Subject: RE: Bovis Homes - Burndell Road

Y/98/18/RE
S

Proposal Approval of reserved matters (access, appearance, landscaping, layout and scale) following outline permission Y/19/16/OUT for 108 residential dwellings, with associated parking, road/footway/cycleway provision, open space, landscaping, surface water attenuation and ancillary works.

PRELIMINARY ENGINEERING LAYOUT

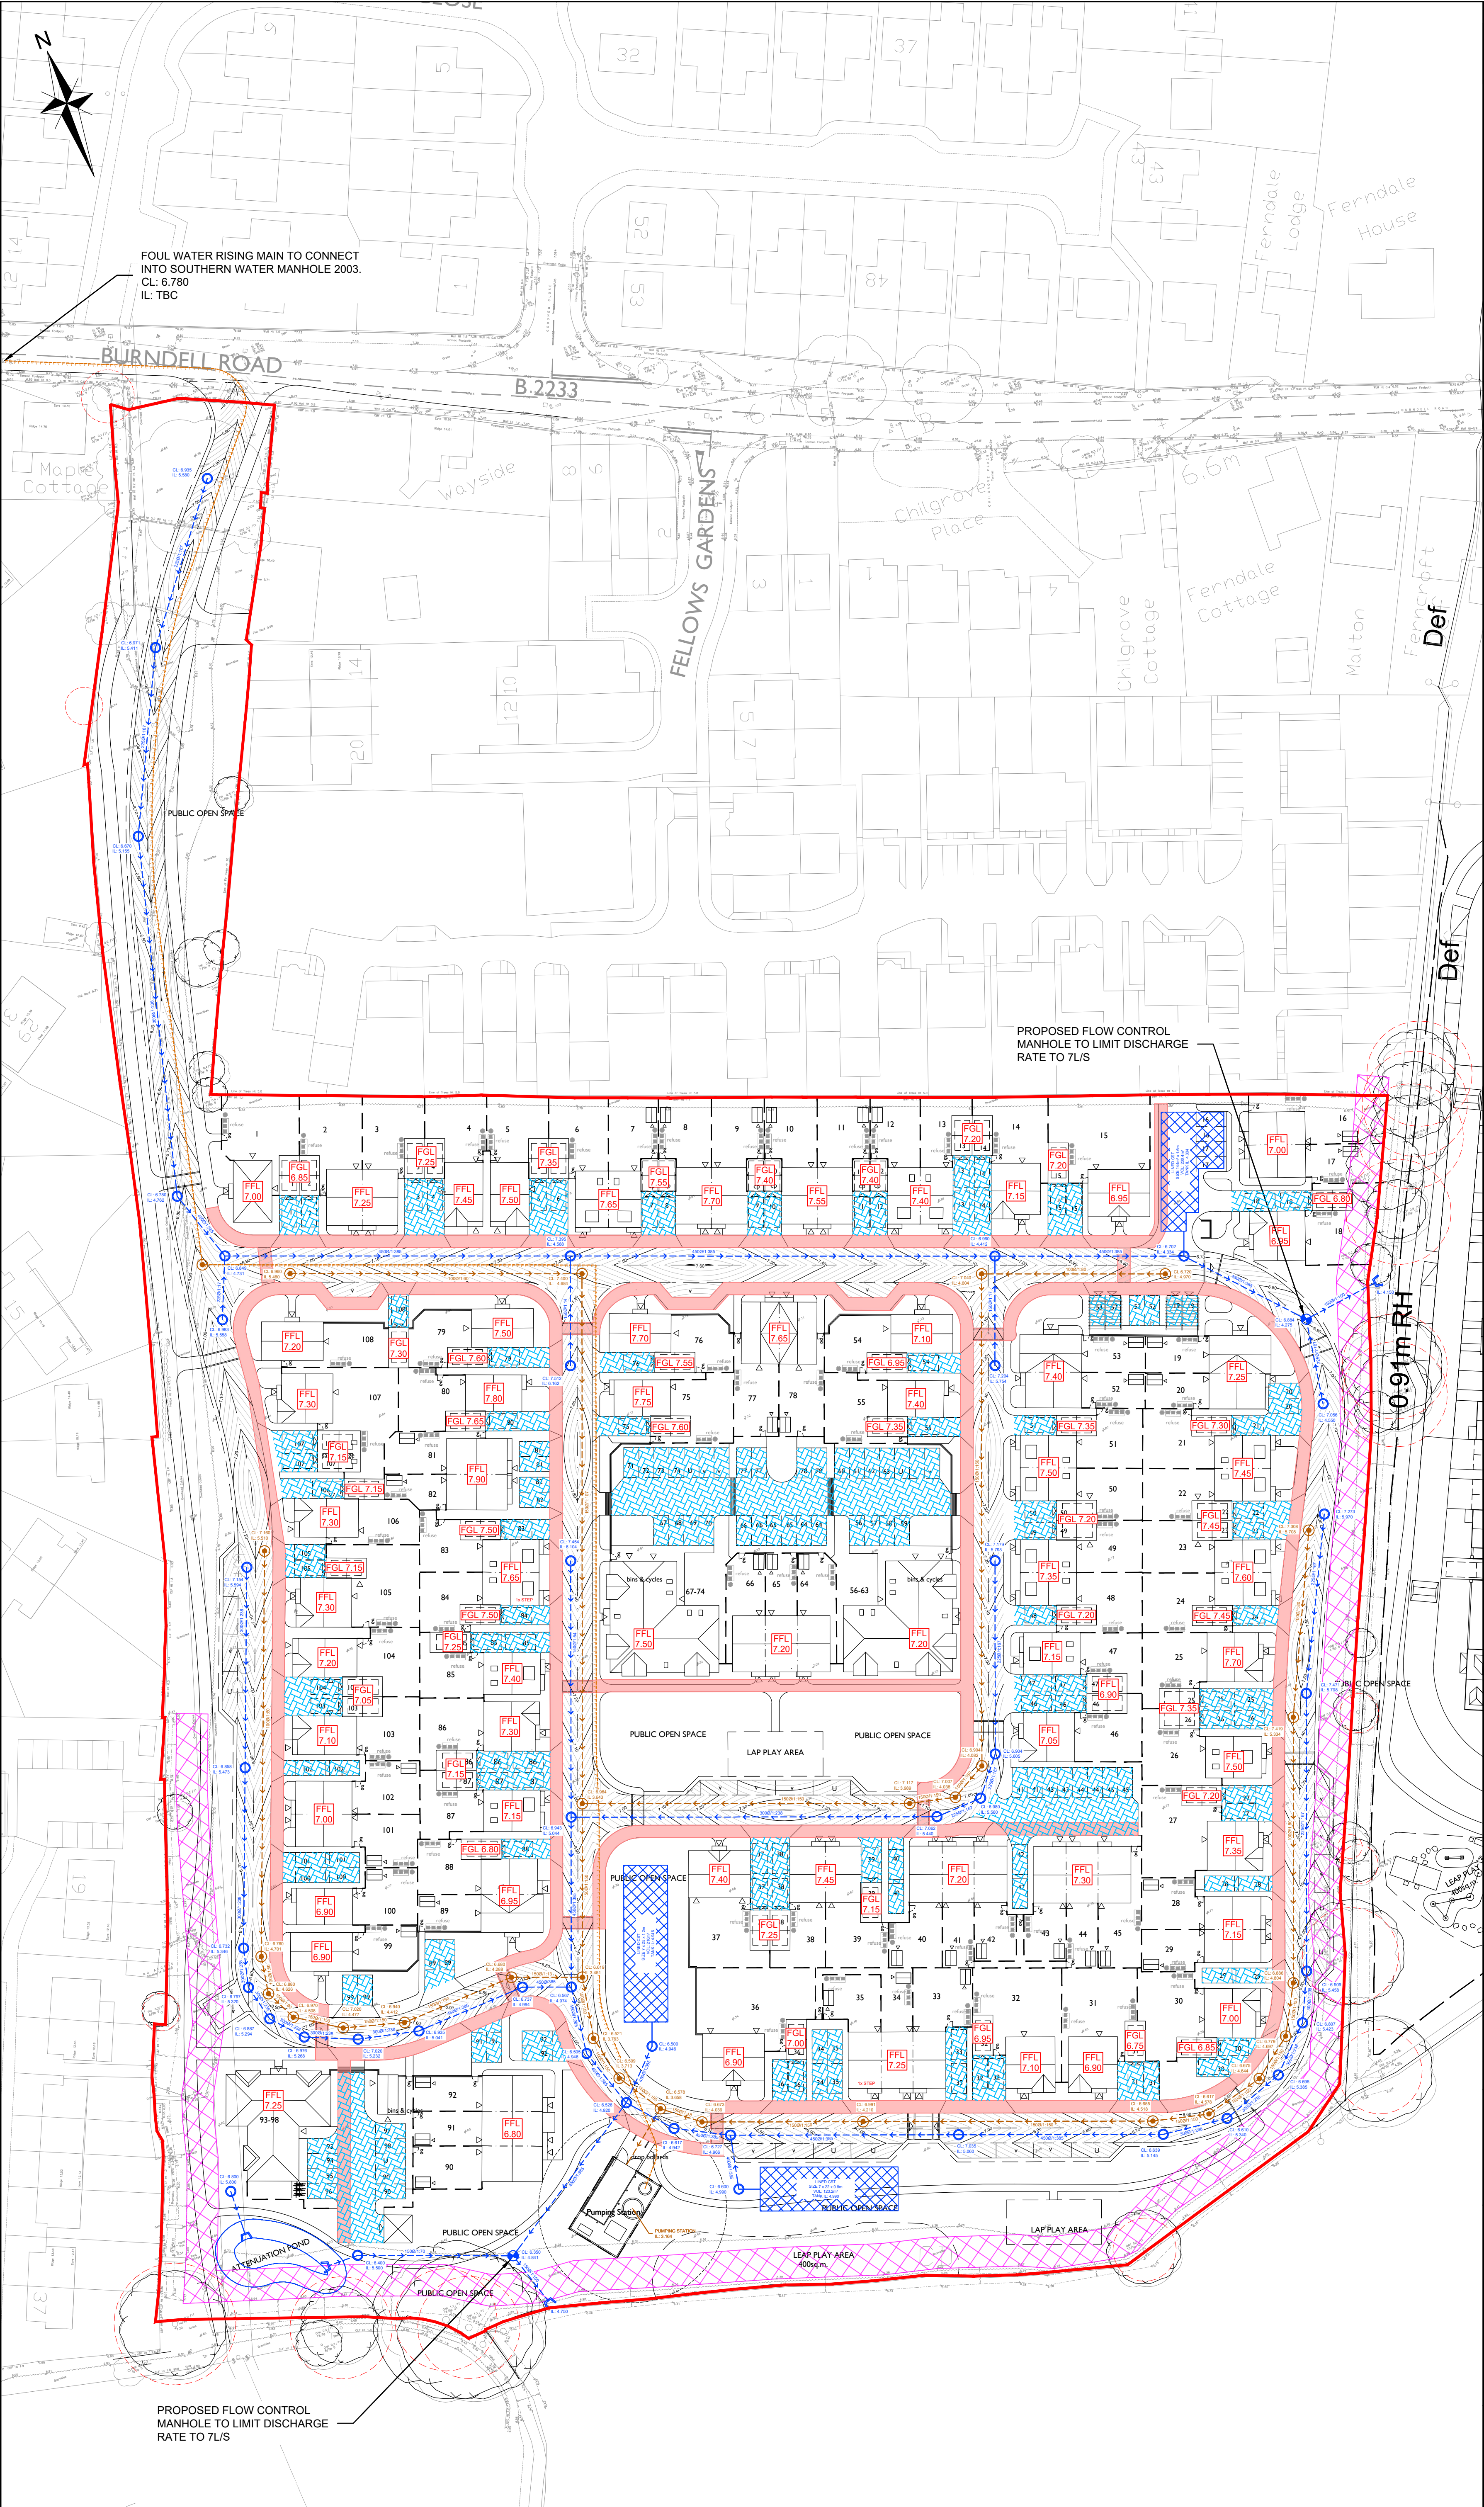
Thank you for the prompt reply however dwg. 18-070-103A is the Preliminary Engineering drawing which mainly covers the site works etc. I have already looked at this drawing which formed part my concerns and objections.

I was trying to find the WSCC Highways Section 278 technical approved drawing for the works on the public Highway, this will showing the kerb alignment changes, road markings and road signs, footway construction and pedestrian crossing points, materials, carriageway tie and changes along with the street lighting positions.

There is a "Preliminary Engineering Layout plan" dwg. 18-070-103A available on Y/98/18/RES which I assume is what you are after.
